KIRKLEES METROPOLITAN COUNCIL INVESTMENT & REGENERATION SERVICE

DELEGATED DECISION TO DETERMINE PLANNING APPLICATIONS

Reference No:	2025/62/91680/W
Site Address:	30, Grasscroft Road, Marsh, Huddersfield, HD1 4LP
Description:	Demolition of existing garage and erection of single storey side and rear extensions including associated works
Recommending Officer:	Joanna Rednall

GROUND FLOOR PLAN

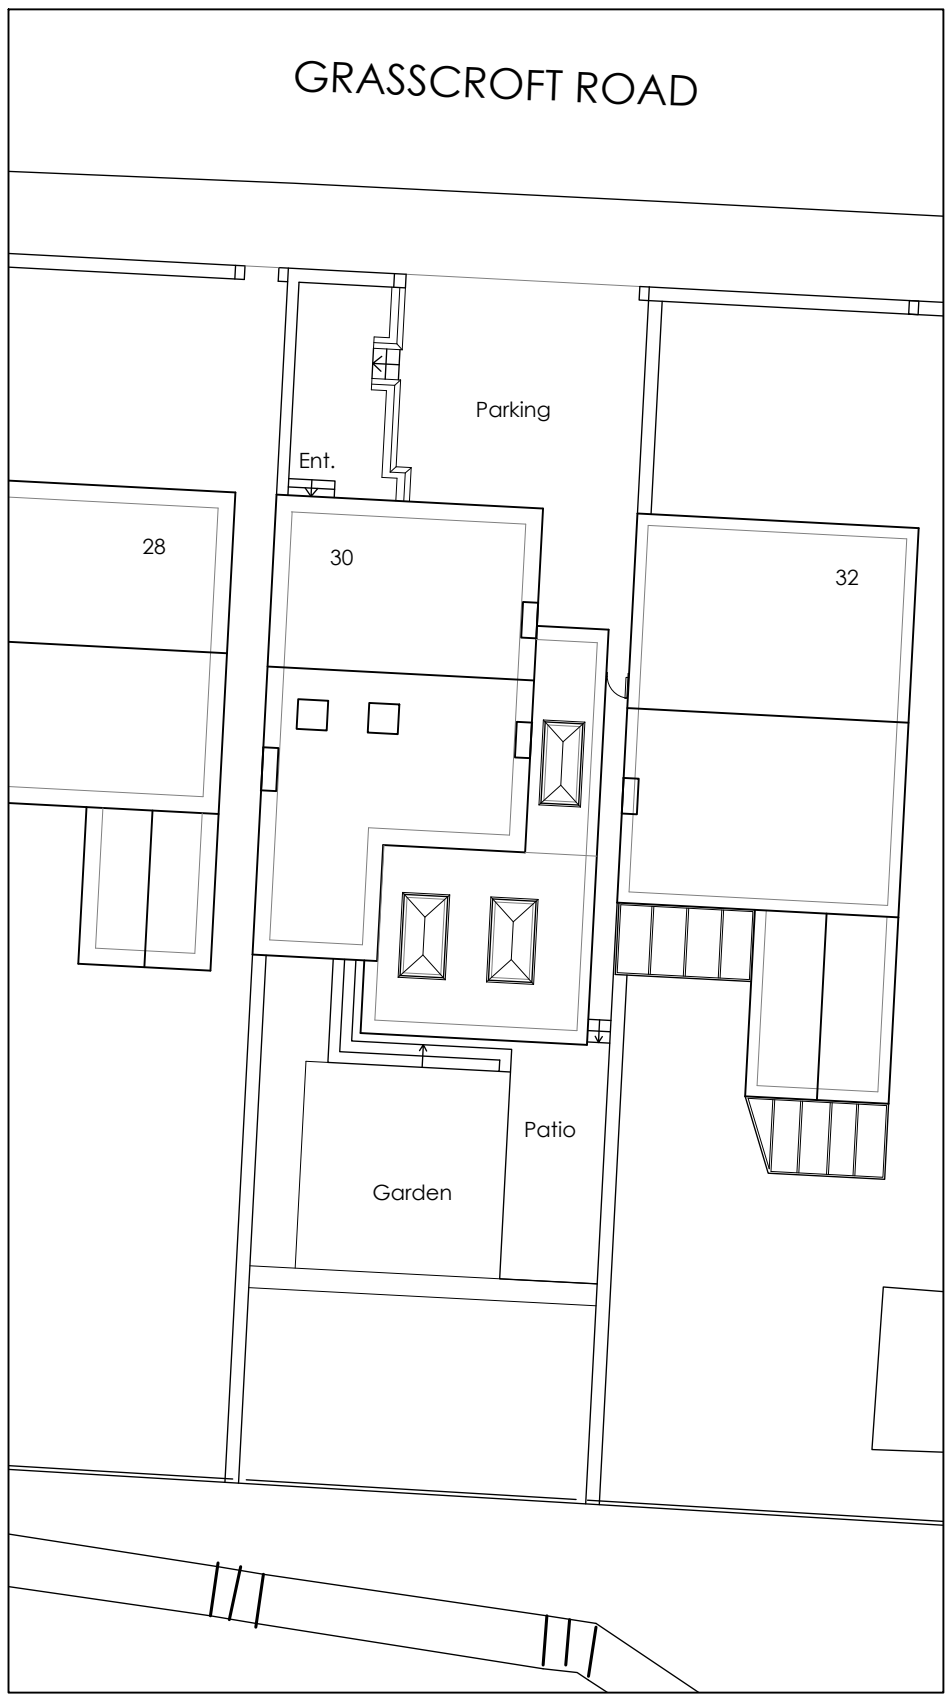
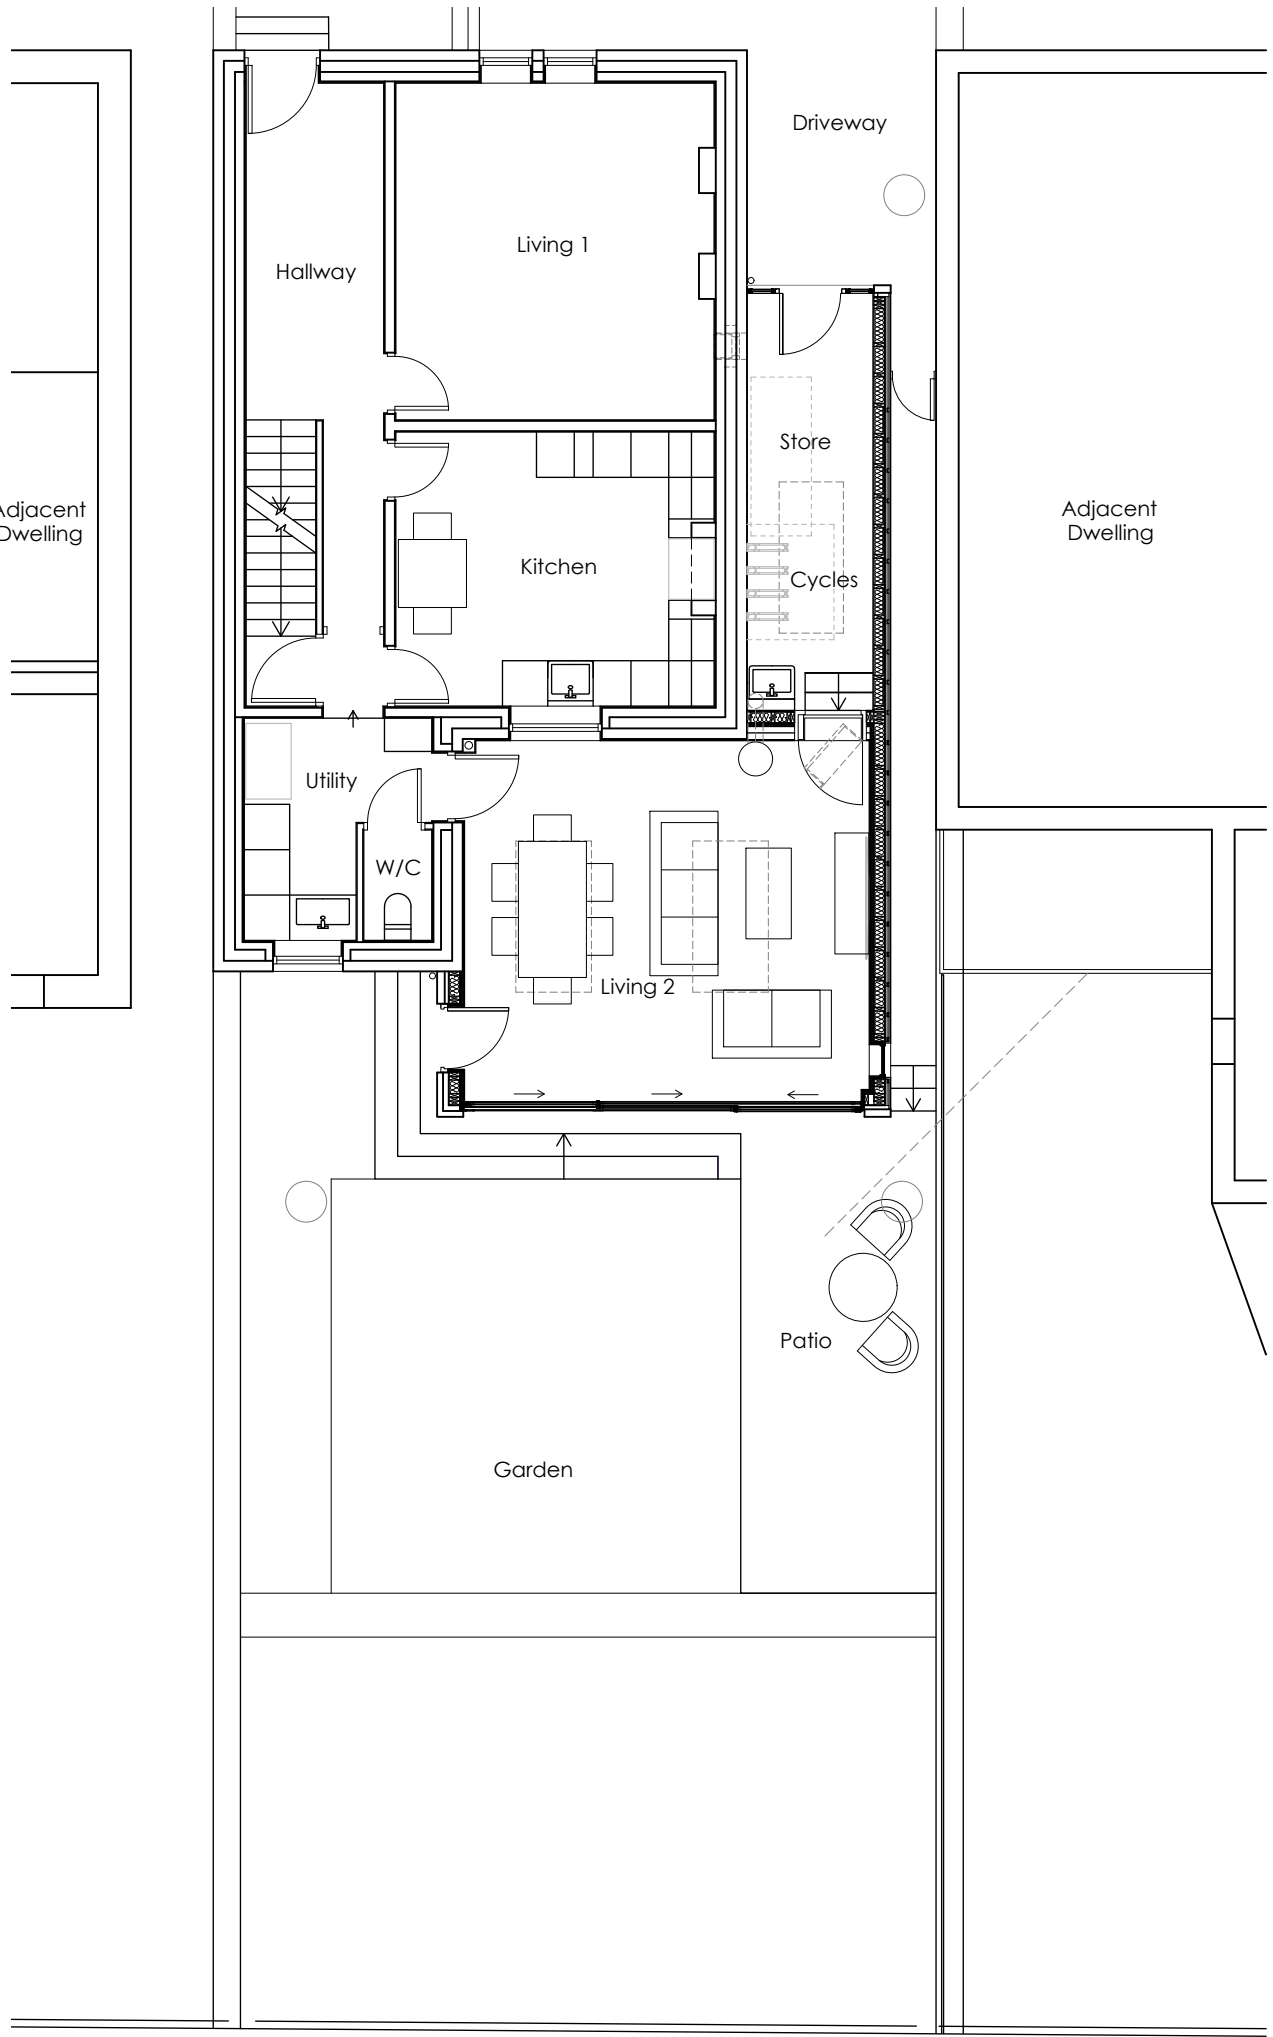
Although the side extension is set 0.6 metres from the shared boundary, it will sit adjacent to existing built form at No. 32 Grasscroft Road. Given this context, it is considered that there is no significant design benefit in increasing the separation to 1 metre, as recommended in the Council's Extensions SPD. A separation would be provided with rear access remaining possible.

The proposed development would extend to within approximately 0.6 metres of the shared boundary with No. 32 Grasscroft Road. However, this element of the extension would be positioned adjacent to the blank side elevation of No. 32, which contains no windows. According to the submitted floor plans, the extension would project approximately 2 metres beyond the rear elevation of No. 32.

The submitted plans demonstrate a 45 degree line is not cut when taken from the centre of the nearest window at no.32. In light of this the proposed extension

NORTH ELEVATION

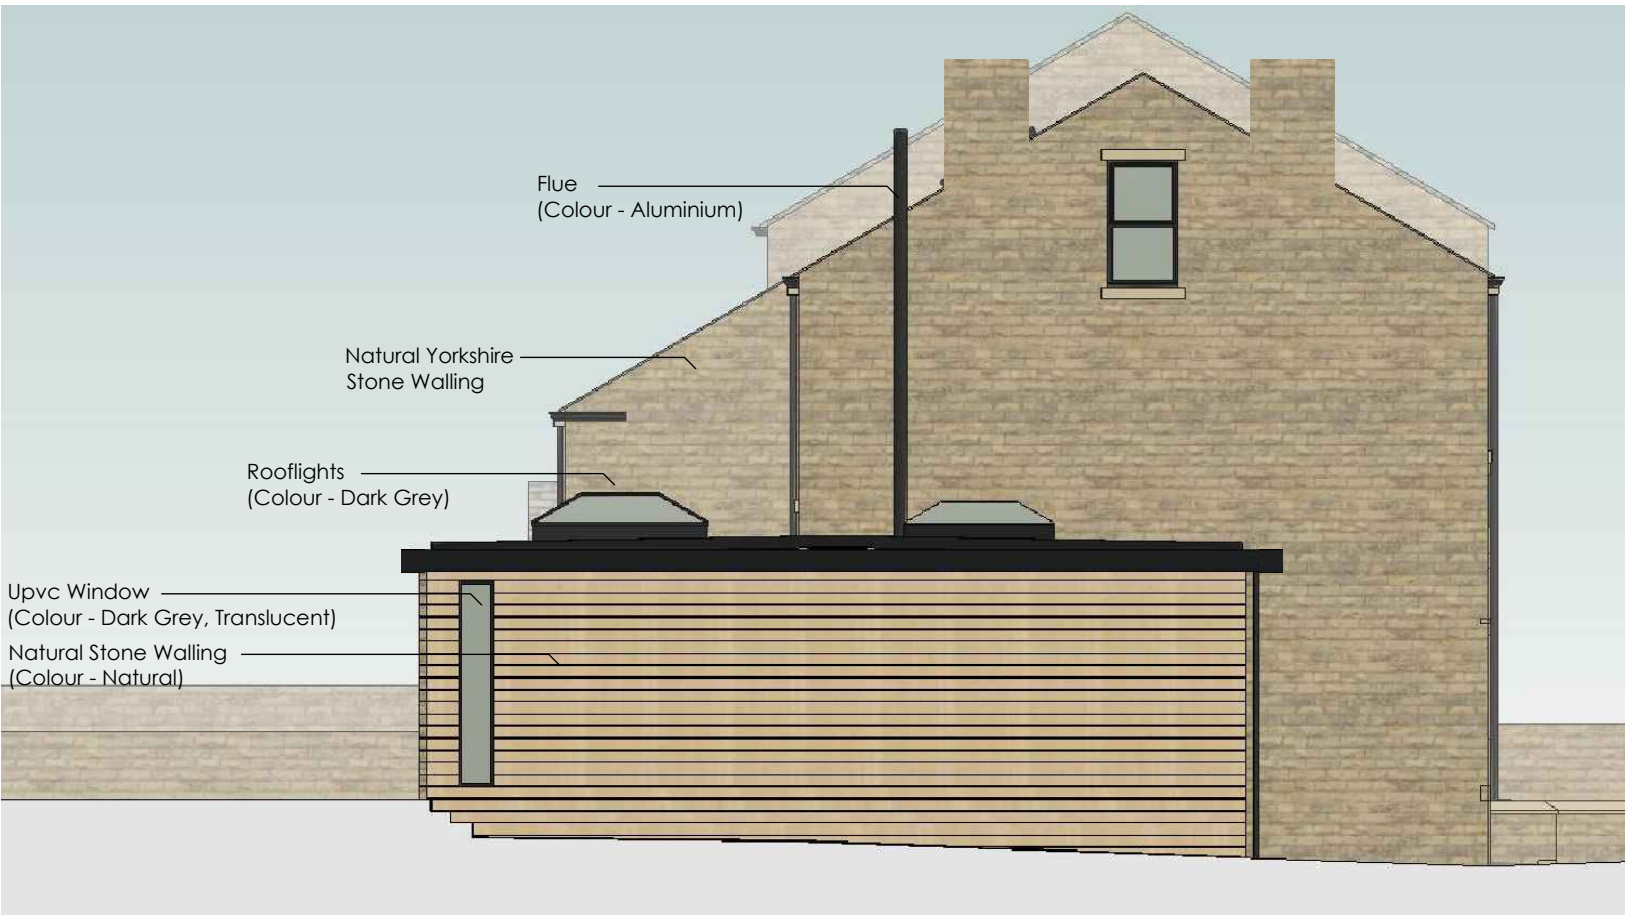
Initial concerns were raised with the applicant’s agent regarding the proposed use of timber cladding, as this material does not reflect the existing palette of the host dwelling or the immediate neighbouring properties. In response, the applicant’s agent provided a justification for the original proposal and subsequently amended the plans to specify natural stone to match the existing dwelling. These revised materials can be secured by condition requiring the

The submitted plans are annotated to detail the use of natural stone for the external wall, and dark grey fenestration which is considered to be acceptable. It is noted a flue forms part of the proposal, the set back position and extent it projects beyond the roof slope is considered to be such that this element of the scheme is concluded to have an acceptable impact. This is taking into account the extent such an element of the scheme could be undertaken by utilising pd rights.

With regard to overlooking, the submitted plans indicate that only one full-height window is proposed on the side elevation of the extension. This window is annotated on the plans as being fitted with translucent glazing. Given this, along with the existing boundary treatment shown on the plans, it is considered that the proposed opening would not result in any unacceptable overlooking or loss of privacy to occupiers of No.32.

development to be undertaken in accordance with the submitted plans and on such a basis, the development is considered to have an acceptable impact on the visual amenity of the area.
